**KIRKLEES METROPOLITAN COUNCIL
INVESTMENT & REGENERATION SERVICE**

**DELEGATED DECISION TO DETERMINE APPLICATIONS FOR
CONSENT, AGREEMENT OR APPROVAL REQUIRED BY CONDITION**

Reference No:	2025/44/91415/E
Site Address:	Shelley Lodge, 2, Box Ings Lane, Shelley, Huddersfield, HD8 0SU
Description:	Discharge of details reserved by condition 6 (Phase II Report) on previous permission 2021/92355 for alterations and extension to existing stables to create dwelling
Recommending Officer:	Nicole Helliwell

DECISION – DISCHARGE OF CONDITIONS REFUSED

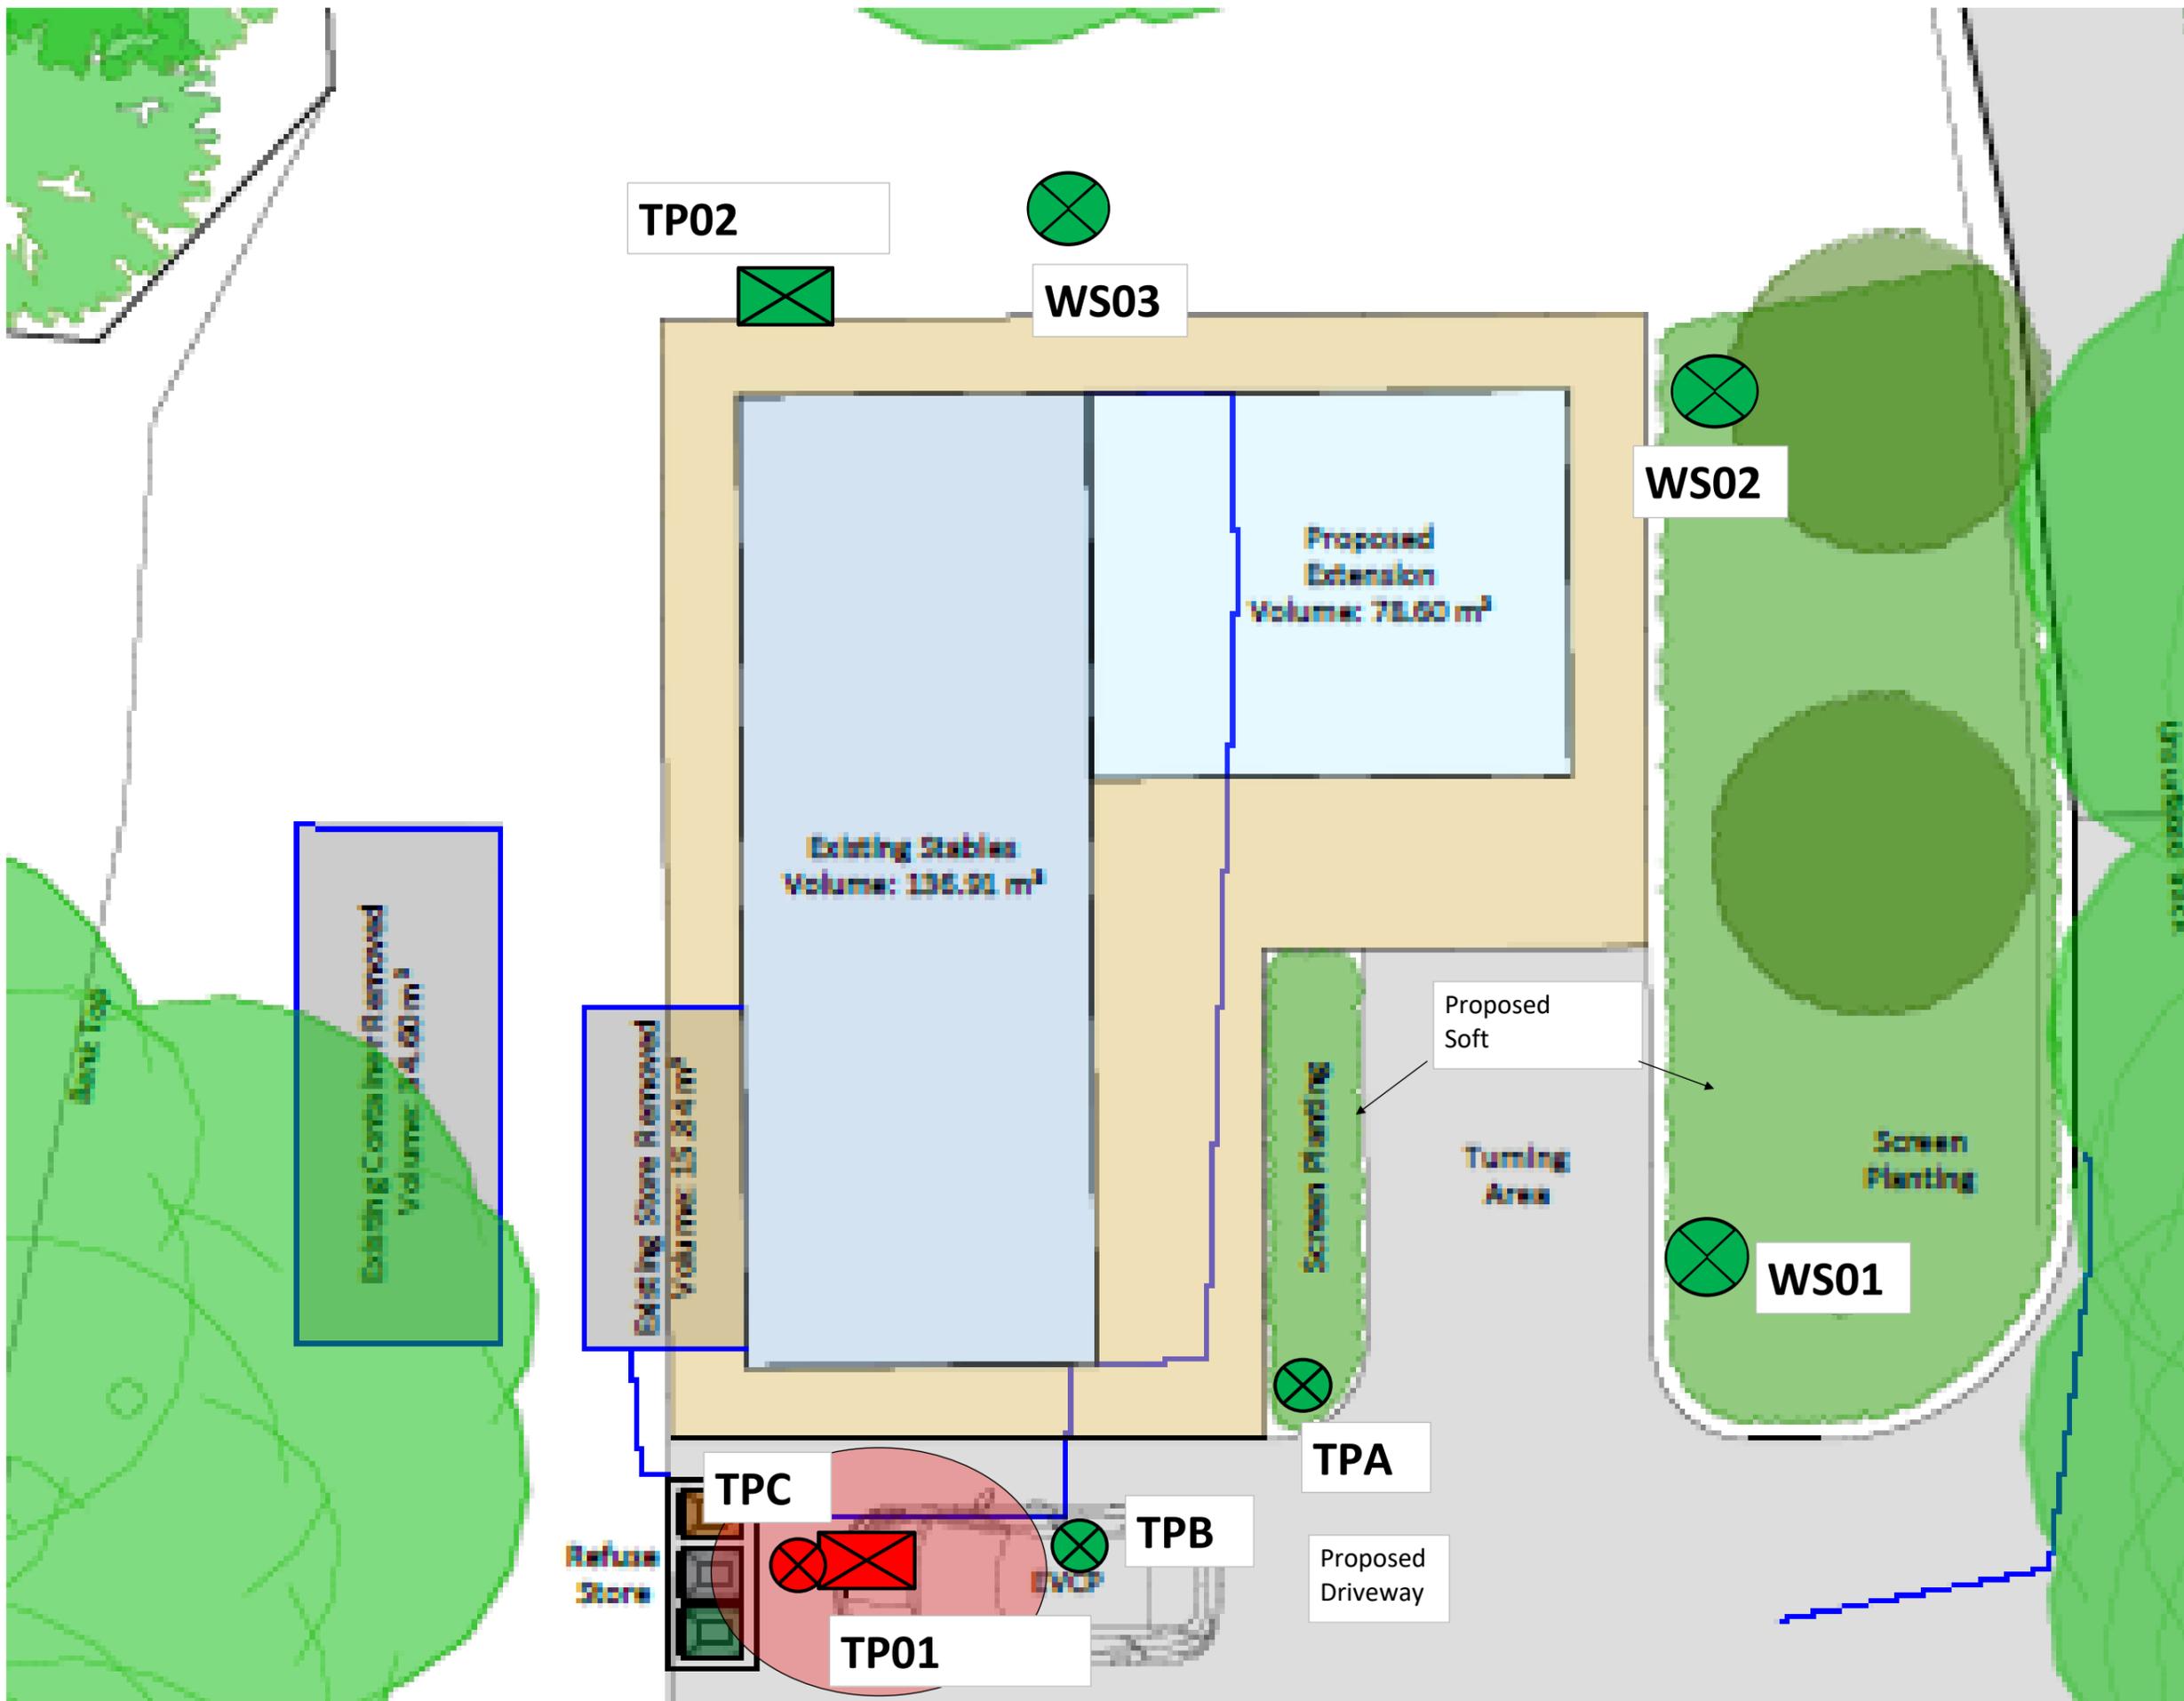
Additional intrusive works included three trial pits (TPA - TPC) to further investigate the extent of previously identified contamination. Elevated concentrations of PAHs were detected within ash-containing made ground beneath the driveway, whereas soils within the soft landscaped areas were suitable for the intended residential use. RGS conclude that the impacted material beneath the driveway presents no risk as it remains sealed beneath hardstanding. While this conclusion appears reasonable, the extent and volume of the impacted made ground have not been clearly defined. It is unclear whether the full lateral and vertical extent of the ash-containing material has

been delineated, or whether all impacted material has been fully encapsulated beneath hard standing. These aspects require confirmation to demonstrate that the identified source–pathway–receptor linkage has been effectively broken. Until these matters are fully addressed, officers recommend that Condition 6 remains in place until further notice.
